Planning Application 15/01326/OUT

Gladman/ Barrett/ David Wilson Homes (DWH) Development

Drawing Number DR-5000 Ref 2832-5-2

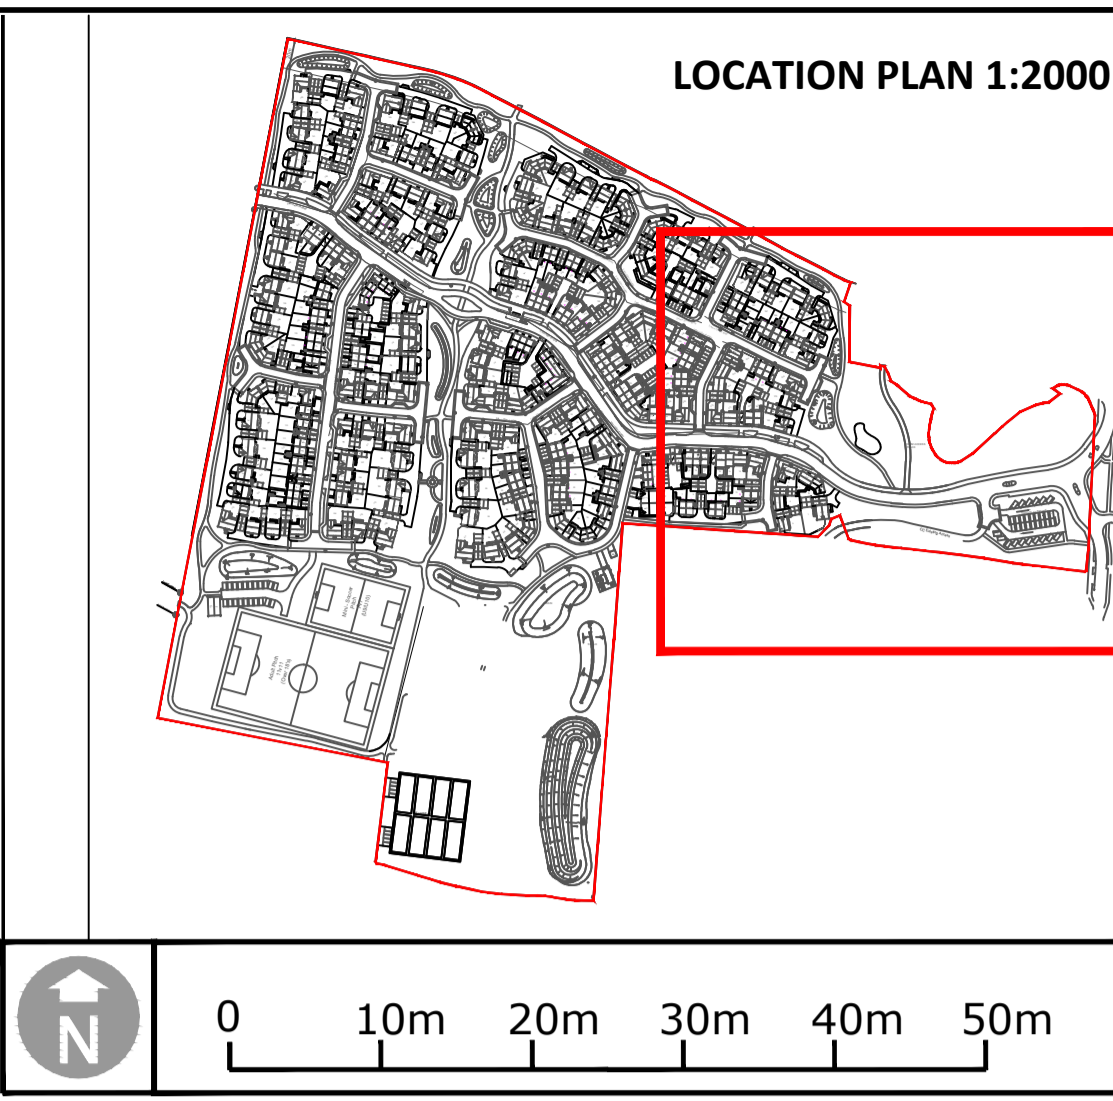
- The identified grass seed sowing mixture for the sports turf is a recreational one that seems to be satisfactory but with BTC sites suffering very wet and boggy conditions how does this mix stand up to moisture in the ground?

- d. Some bulb planting has been proposed however these appear to be thin strips, which like the mounds will not look natural and will provide a poor display. Bulbs in grass need to be in large drifts wherever possible to make a big impact otherwise they are a maintenance problem.

- e. The plan shows mown grass paths which is not financially or practicably possible in areas that are closely mown areas anyway.

Drawing Title
HARD, BOUNDARY & FURNITURE PROPOSALS (SHEET 2 OF 3)

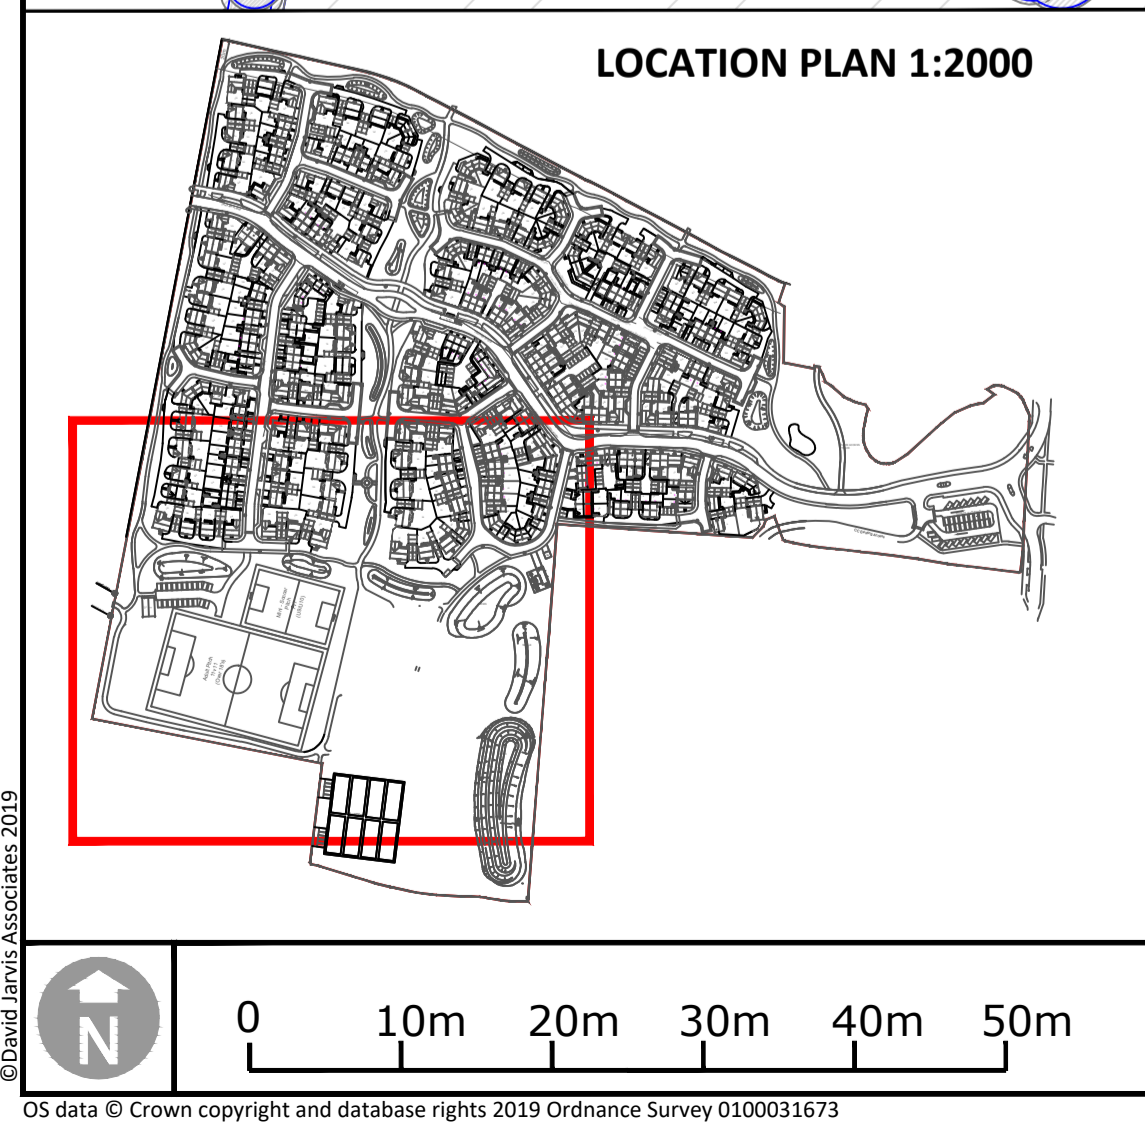
- 4. I have noted that there is a proposal to install a 1.2m high metal fence across the western side of the estate with stone pillars. As all the open space will be transferred to a local authority this seems a waste of money and superfluous. It is not as if this will be a private estate that will have security guards around and patrolling it?

10. The proposal is for a timber post and rail fence around the site with "Matching Gate". On all our sites the fencing has been improved due to vandalism and theft with security steel palisade fencing; this proposal is not suitable for this site.

- b. In the key it mentions a water trough but this is not shown on the plan? Water will be required for the allotment holders. It would be great if some form of underground reservoir could be built to hold water for when it would be needed either to irrigate areas on the pitches (following end of season reinstatement), use on the allotment site or to provide for the water feature?
